Subject: Further DOCO comments for application 2026/90857 at HSBC, 2 Cloth Hall Street, Huddersfield, HD1 2EG

I have reviewed the newly submitted plans:

- Proposed Elevations (North and East), Drawing No. 18, Revision D dated 09.26
- Proposed Elevations (West and South), Drawing No. 17, Revision C dated 09.26
- Proposed Ground Floor Plan, Drawing No. 10, Revision G dated 09.26.

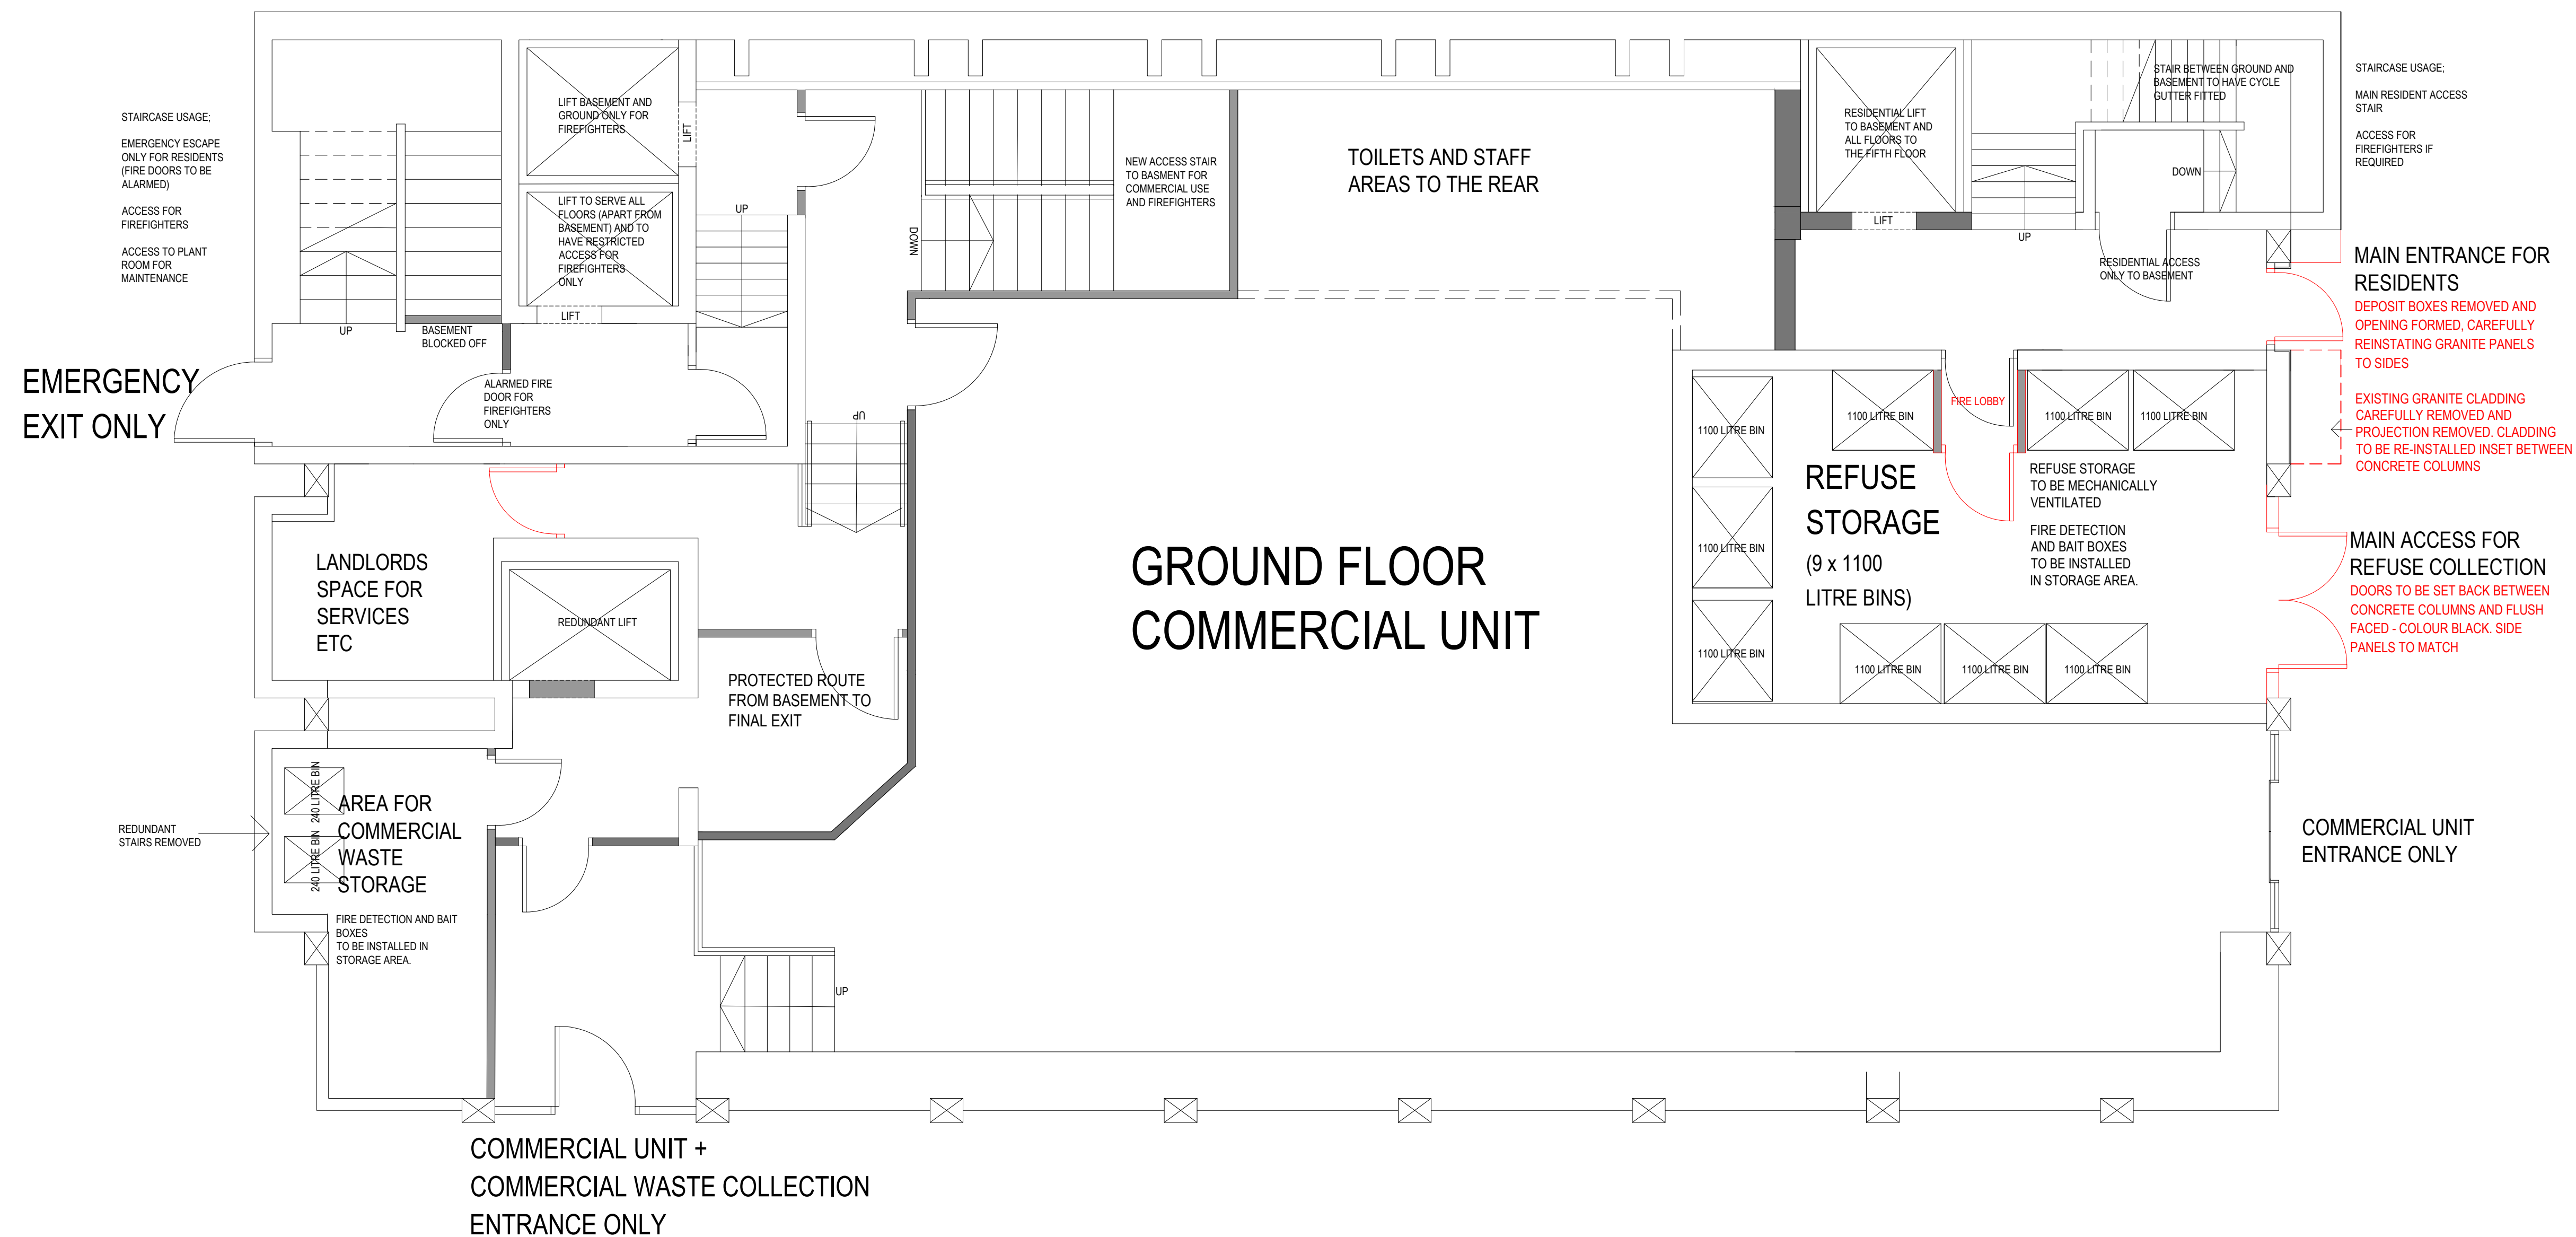
I note that the main entrance for residents is no longer located in a large recess- this is appreciated and certainly a positive amendment from a crime reduction perspective. The main residential entrance, main access for refuse collection and commercial unit entrance are now more aligned which should improve their visibility to passing footfall and offer some deterrent against anti-social behaviour.

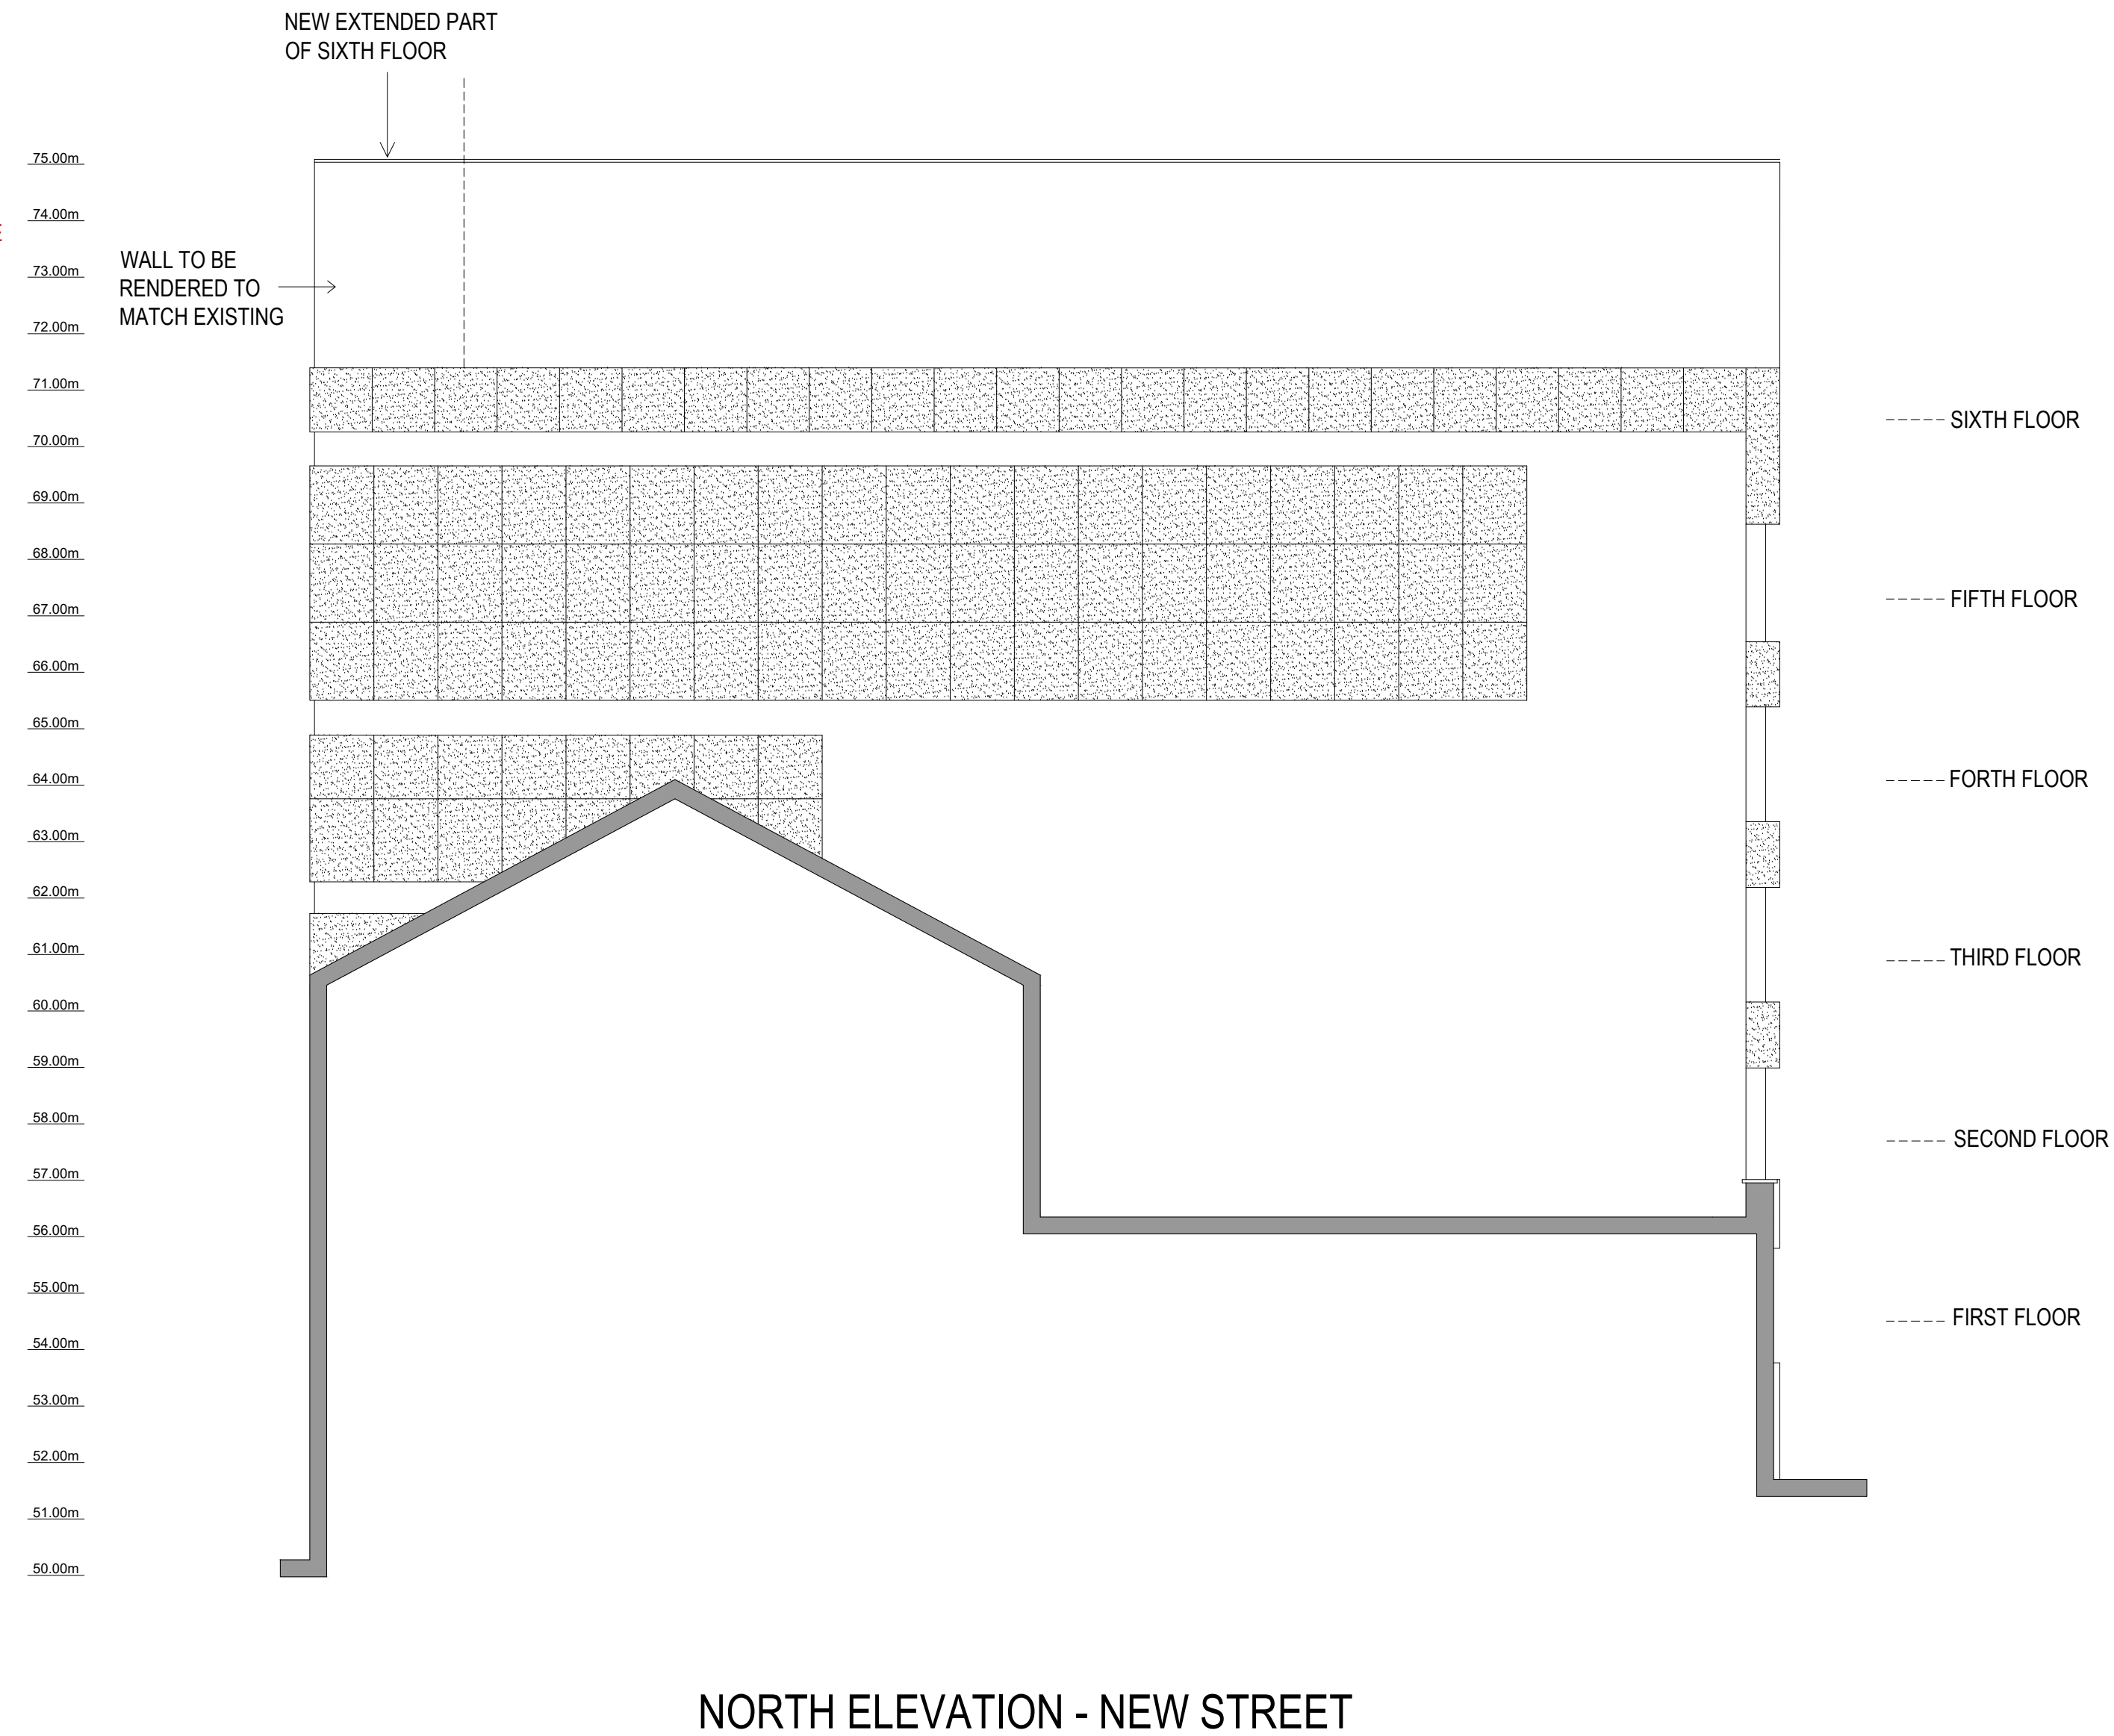
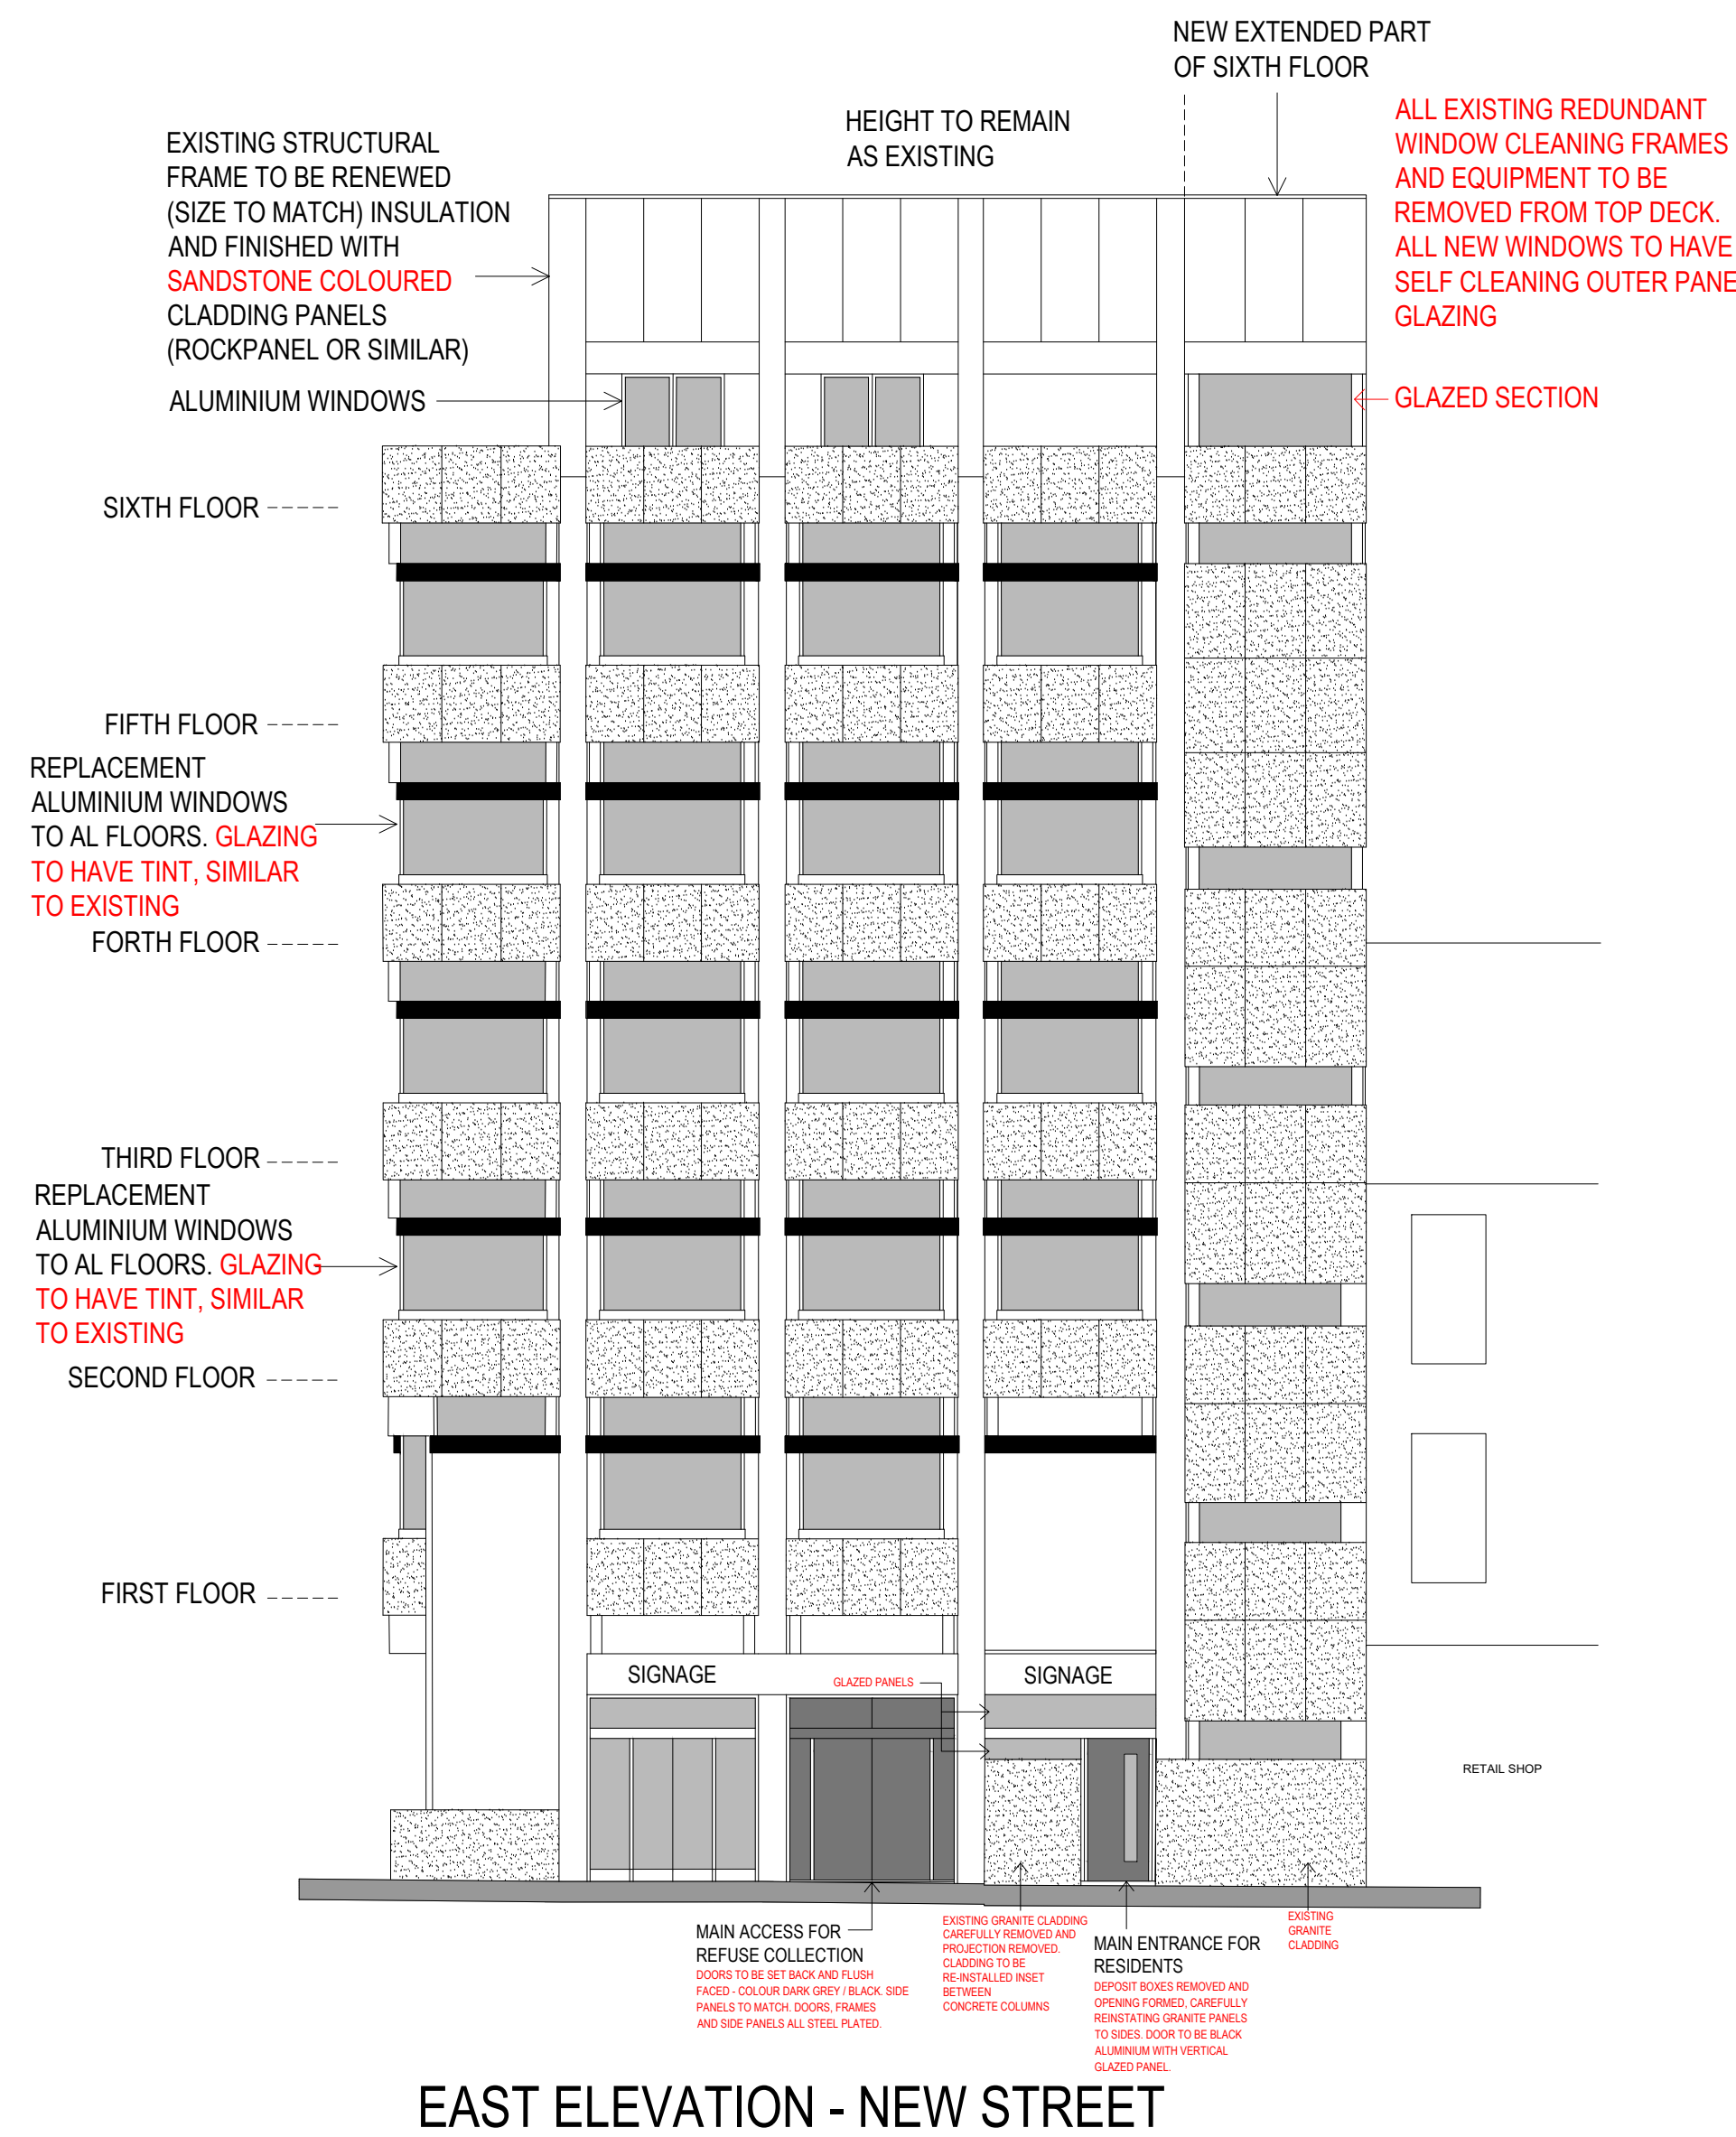
The glazed panels (marked with blue stars below) are easily accessible. Therefore, they need to incorporate 1 pane of laminated glass (minimum thickness 6.8mm) or glass certified to BS EN 356:2000 Class P1A or above.
